Laund Road, Salendine Nook Stage 1/2 Road Safety Audit

May 2018

Project 1387

DRAINAGE PLAN & DETAILS

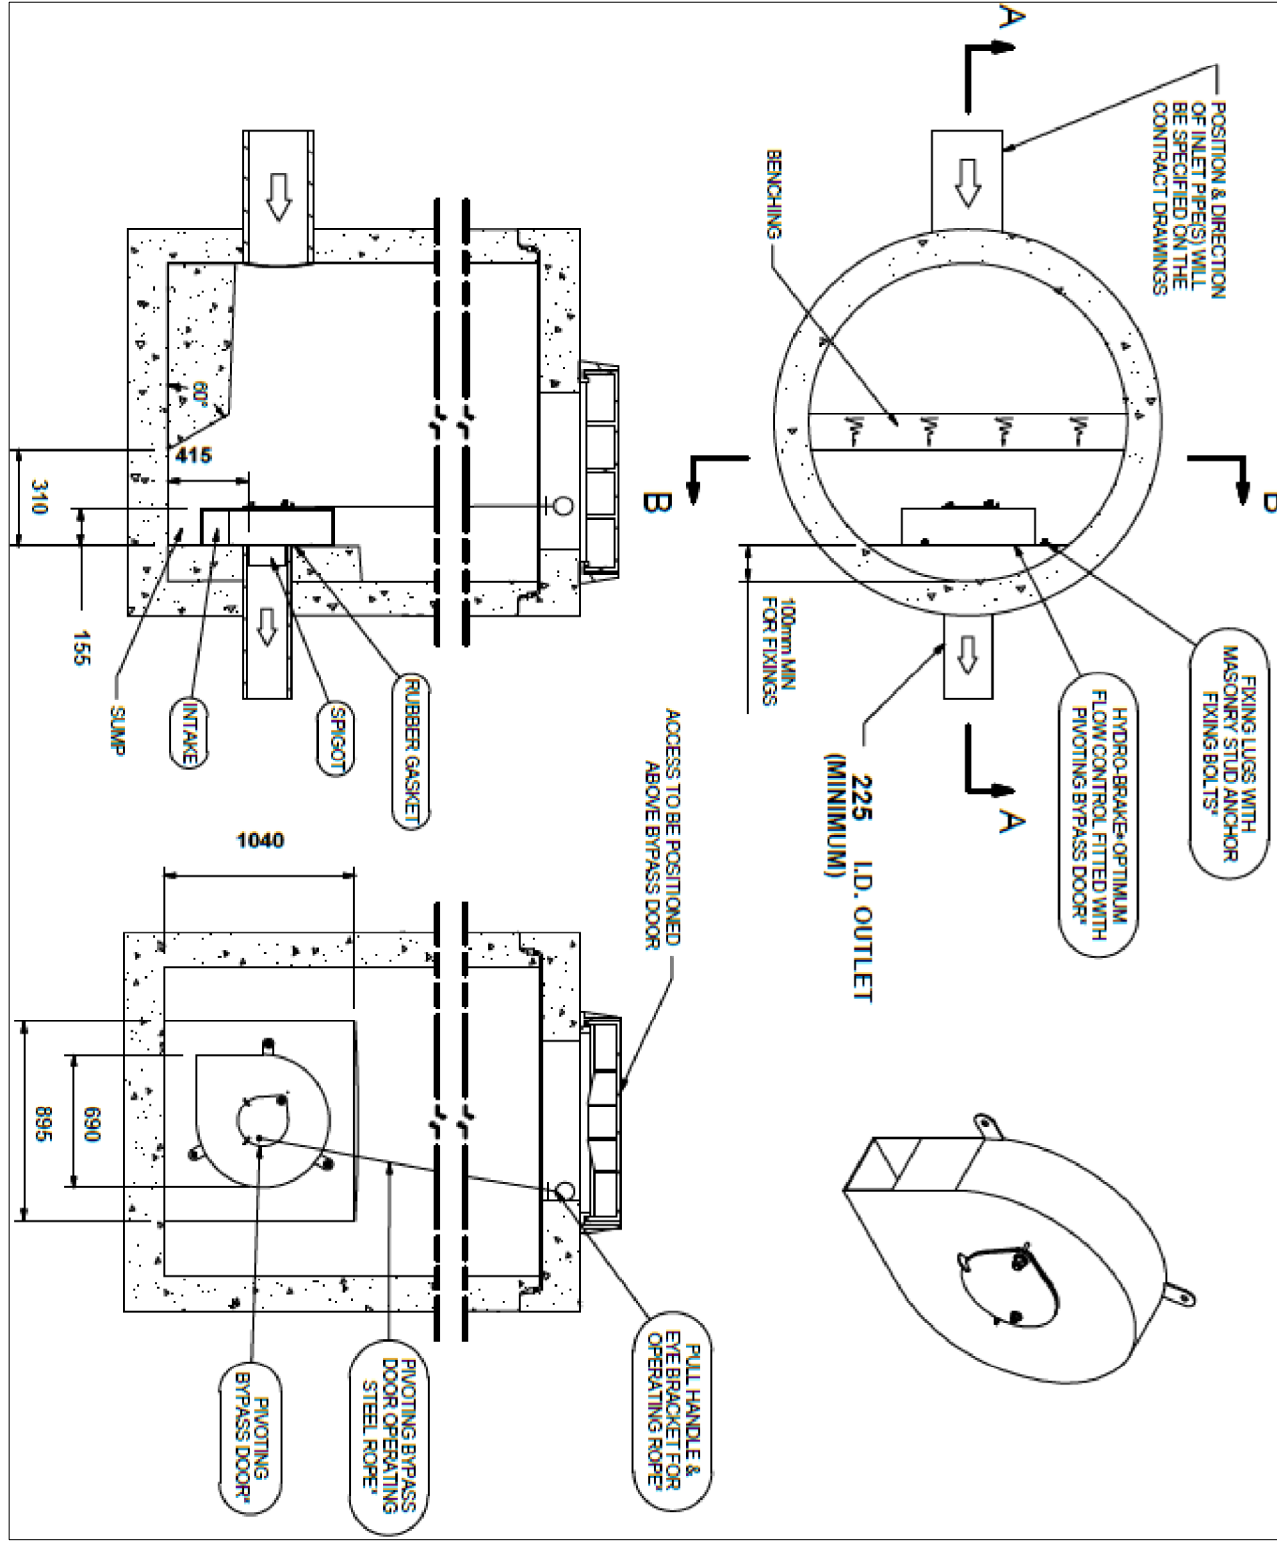
Detail: The drawings show a narrow block paved margin with a vehicular dropped crossing and edging in front of the existing driveways that lead to the stone cottages. It appears that the road and surface water will fall in the direction of these properties. There is only one gully specified along this section and there is concern that during heavy rainfall this will not be adequate to catch all the surface water.

Recommendation

Ensure the drainage and gullies are adequate to catch the expected amount of surface water from the highway.

Detail: No detail has been provided regarding the access arrangements at the new junction. The drainage drawing indicates a different layout to the Section 38 drawing; which shows the footway on Laund Road continuing through the new junction without any provision for pedestrians. If the footway does continue there is a risk that pedestrians will not be aware of vehicles emerging from the site or if it is proposed as a standard junction layout, then no details are shown for pedestrian dropped crossings.

120 LAUND ROAD, SALENDINE NOOK		DRAWN BY MB
SECTION 38 DESIGN AND LONG SECTION		CHECKED BY AH

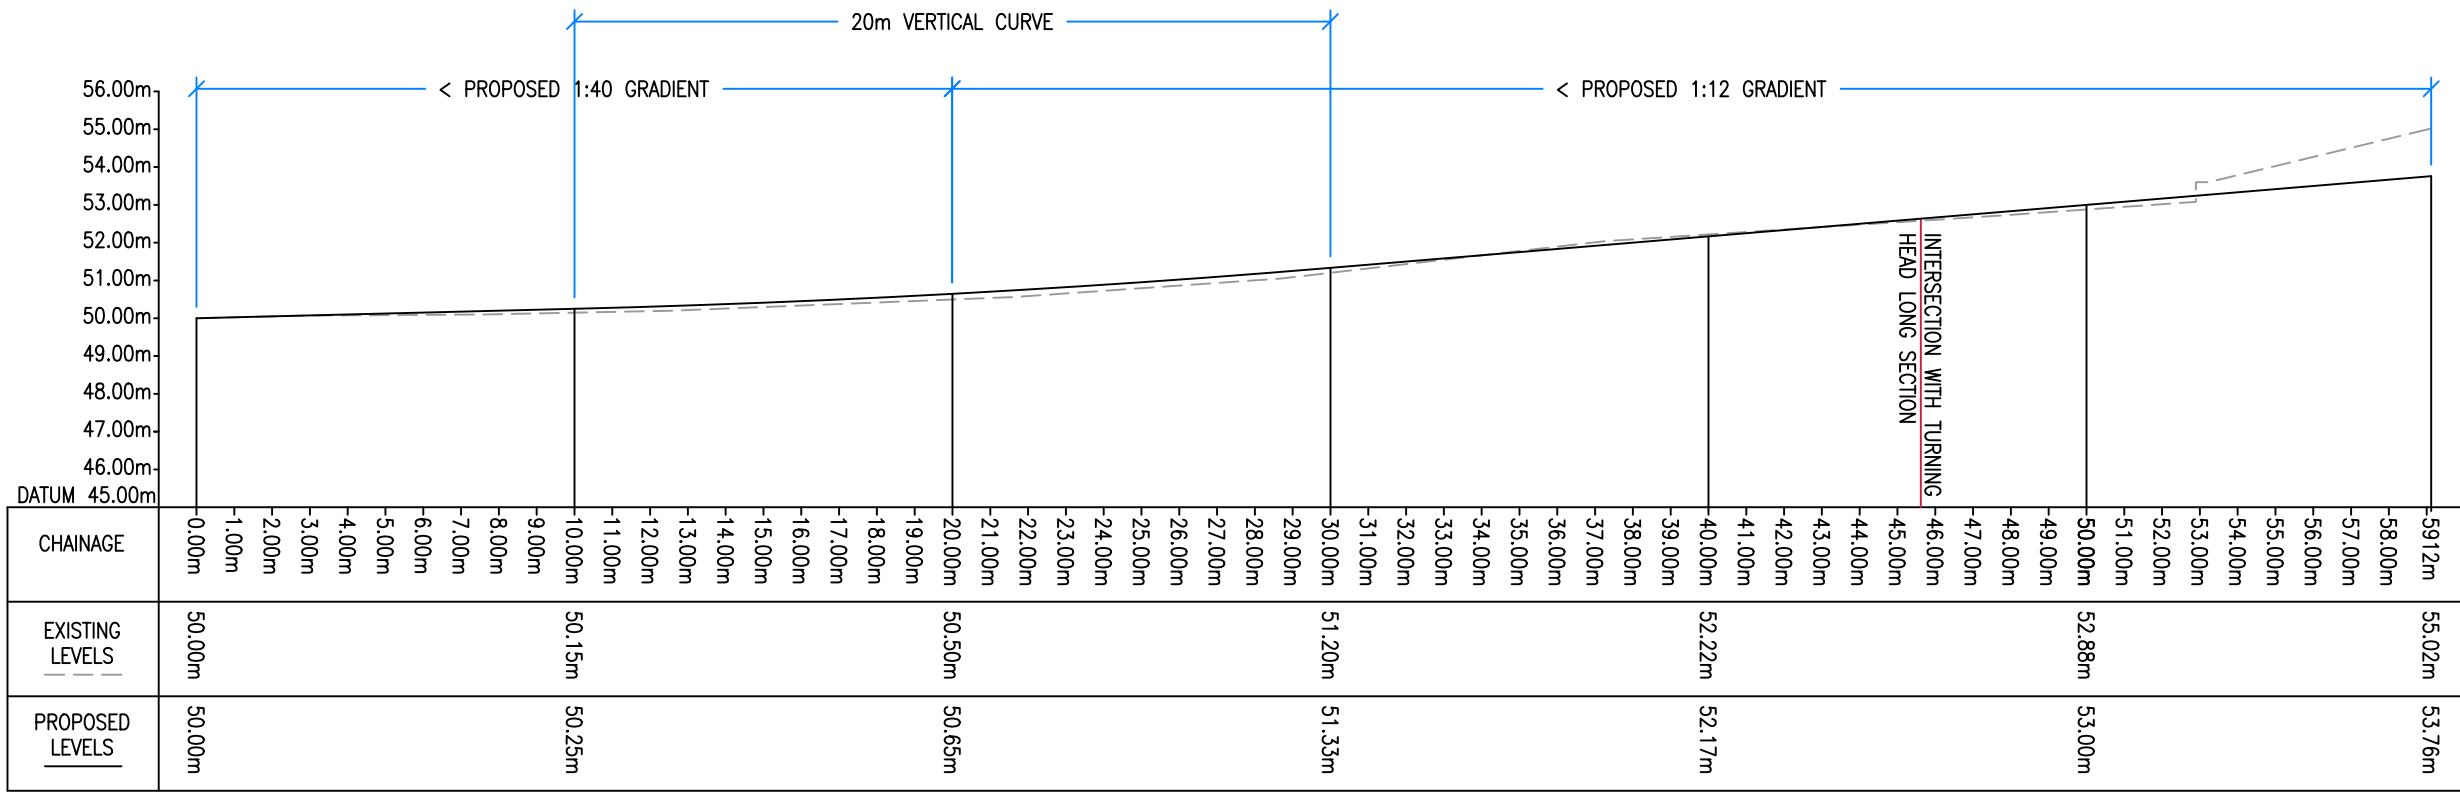
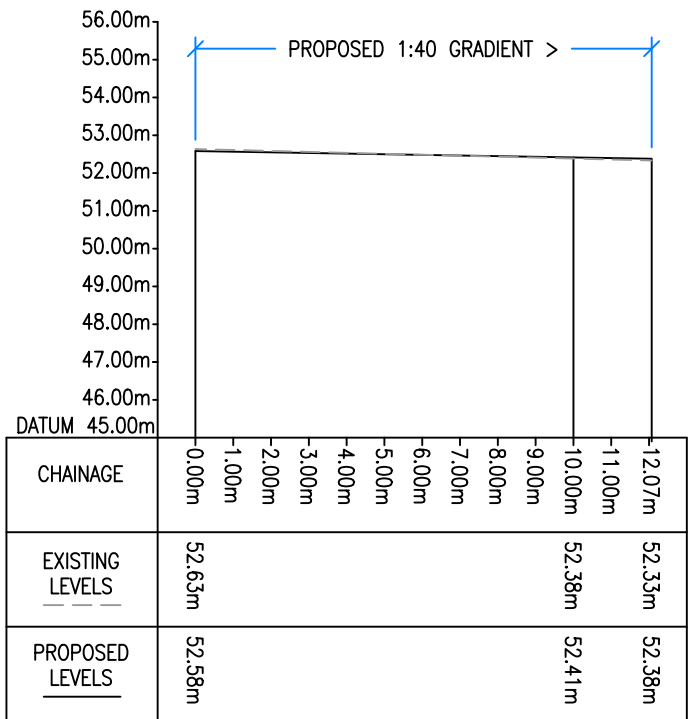
Location: New Access Road from Chainage 20 into turning area.

Summary: Steep gradient may cause pedestrian slips, trips and falls during inclement weather and / or collisions with vehicles.

Detail: The gradient is more than the maximum as recommended in the Standards and may cause safety issues particularly for pedestrians as there is no footway provided. During inclement weather if the road is icy and pedestrians are using the carriageway they may slip or conflict with vehicles also unable to drive safely on the incline.

Recommendation: Ensure the gradient of the road is acceptable for this type of development.

Detail: The proposal indicates a 0.3 metre block paved margin around the edge of part of the new access road. This is below the standard recommended width of 0.6 metres and may create a safety issue for pedestrians particularly at the pinch points where the carriageway is only 3.1 metres wide. The road leading to dwelling no's 5, 6, 7 & 8 does not show any provision for a margin.

Recommendation: Ensure the margin and provision for pedestrians is adequate for this type of development.
